From: Anita Gardner
Sent: 17 May 2018 17:03
To: Karen Parsons
Subject: FW: A/31/18/OUT- EOT agreed- propose GIFA reduction

From: Charlotte Smith
Sent: 09 May 2018 11:00
To: Anita Gardner
Subject: A/31/18/OUT- request for feedback

From: Charlotte Smith [REDACTED]
Sent: 08 May 2018 15:36
To: Laura Gibbons
Cc: Anita Gardner
Subject: A/31/18/OUT- revised surface water drainage as requested

TITLE:
SITE BLOCK PLAN

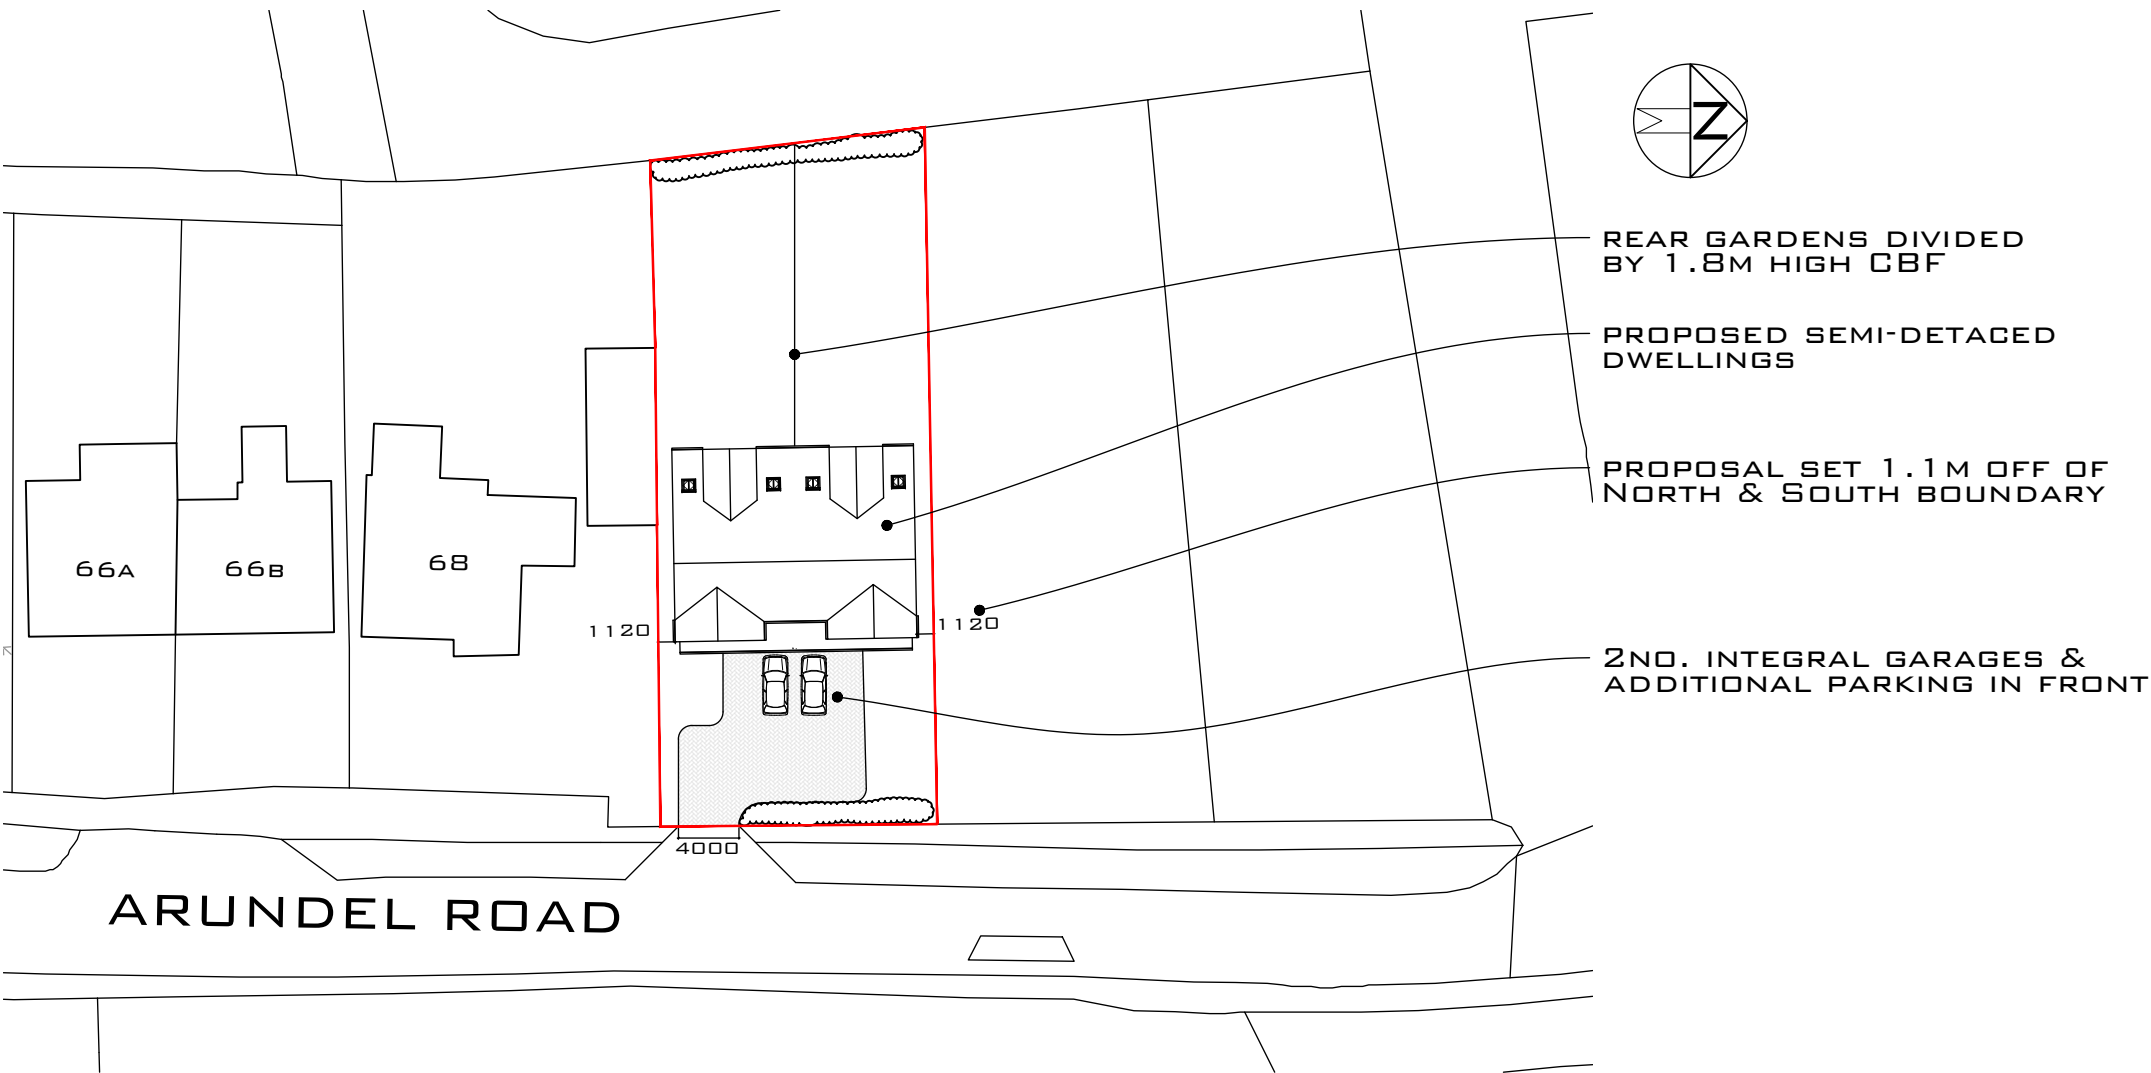
There is a Parish Council objection to the application. If my recommendation is contrary to this i.e. in support of the proposal the application would need to be determined at Committee. I do have reservations about the amount of development on the site and need to discuss the application with my Team Leader before I will know if the decision will be made under delegated powers or by Committee.

At first look it is thought a footprint reduction of around 10% would be viable.

Please let me know if a process of negotiation will be possible and in that case we shall revise the drawings for your consideration.

Client
Chesterman Homes
Drawing Title
Surface Water Drainage

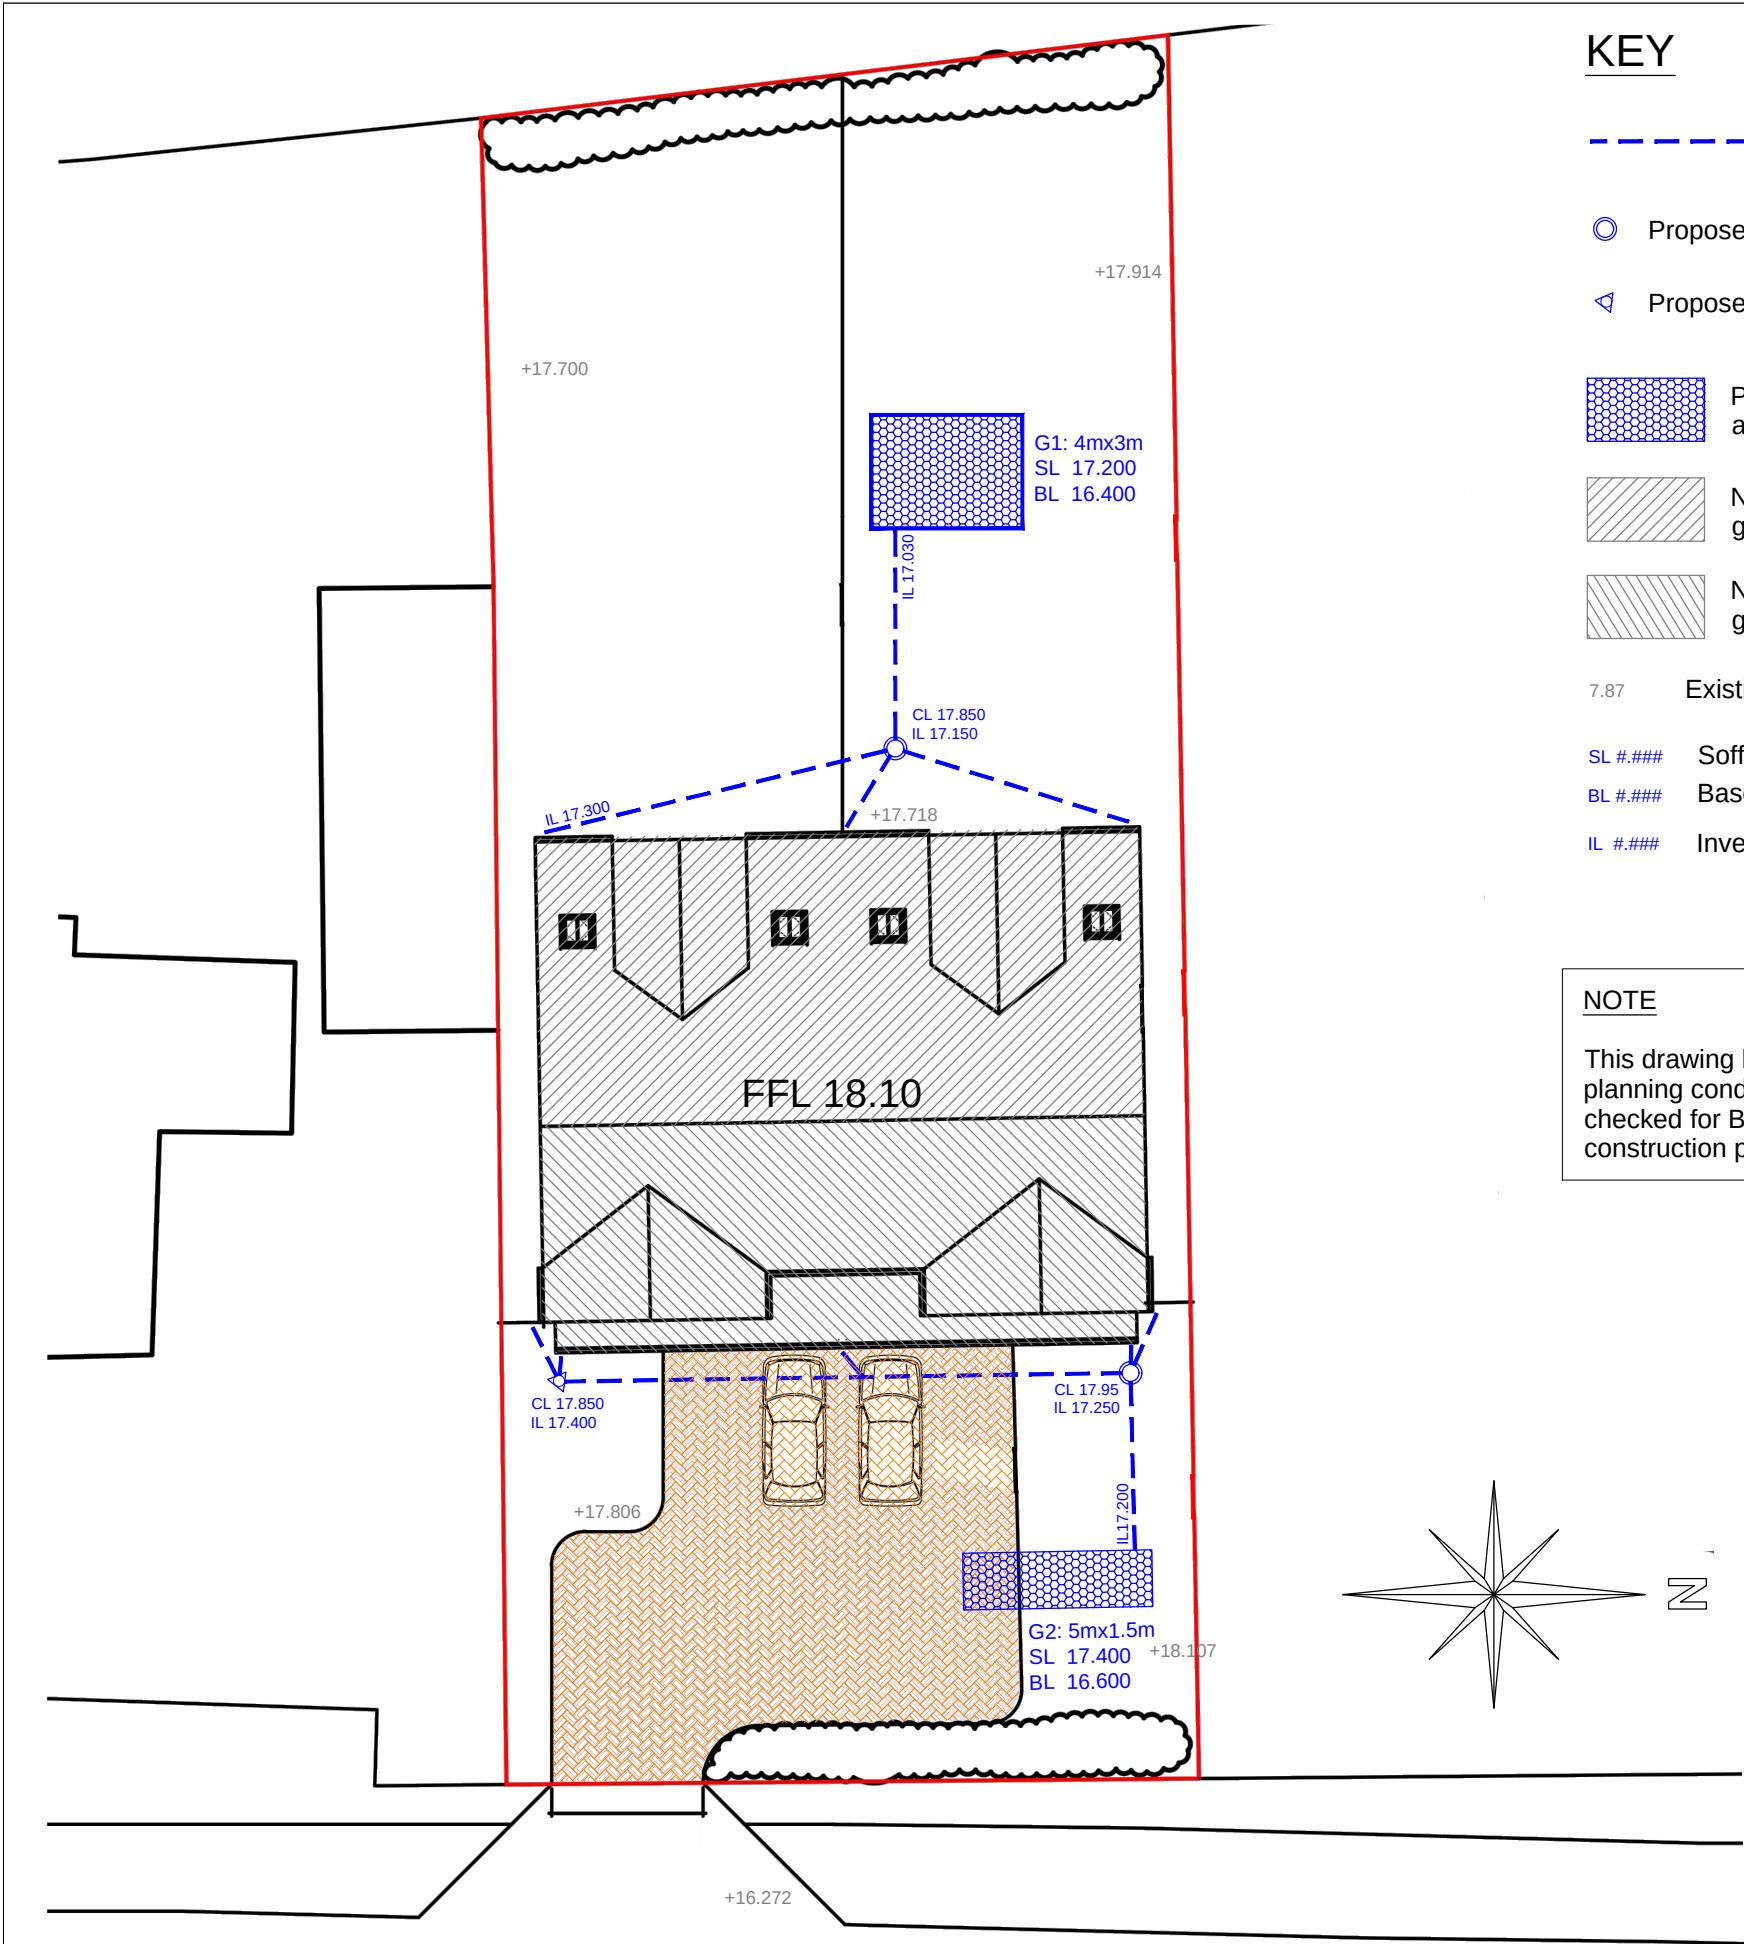
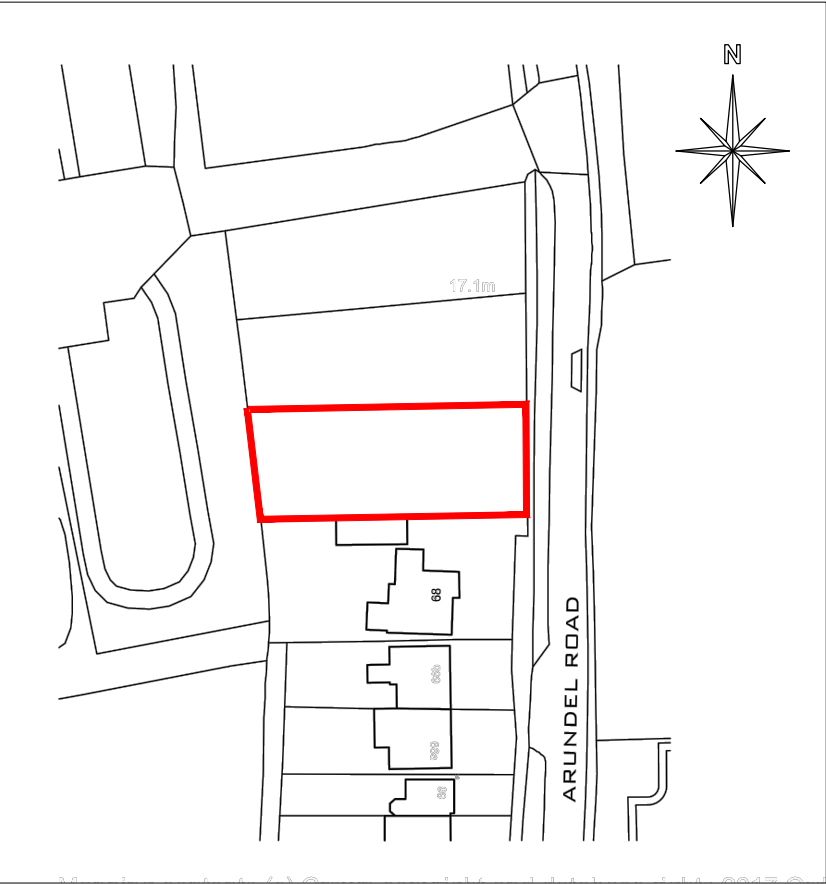
The plans need to be updated to state that the rear soakaway will have a base level of 16.6mAOD, i.e. that of the highest recorded ground water level, and to tie in with the revised calculations provided.

Charlotte- Thank you for the explanation. That is fine. The drawings don't need to be updated.

The rear soakaway has been set at 16.4m AOD to found it well into the gravel but the calcs are based on the highest recorded groundwater level of 16.6m AOD. If we specify a base level of 16.6m AOD for the soakaway, this will require 600mm of crates, which are not readily available, so we thought best to use standard 400mm crates in 2 layers.
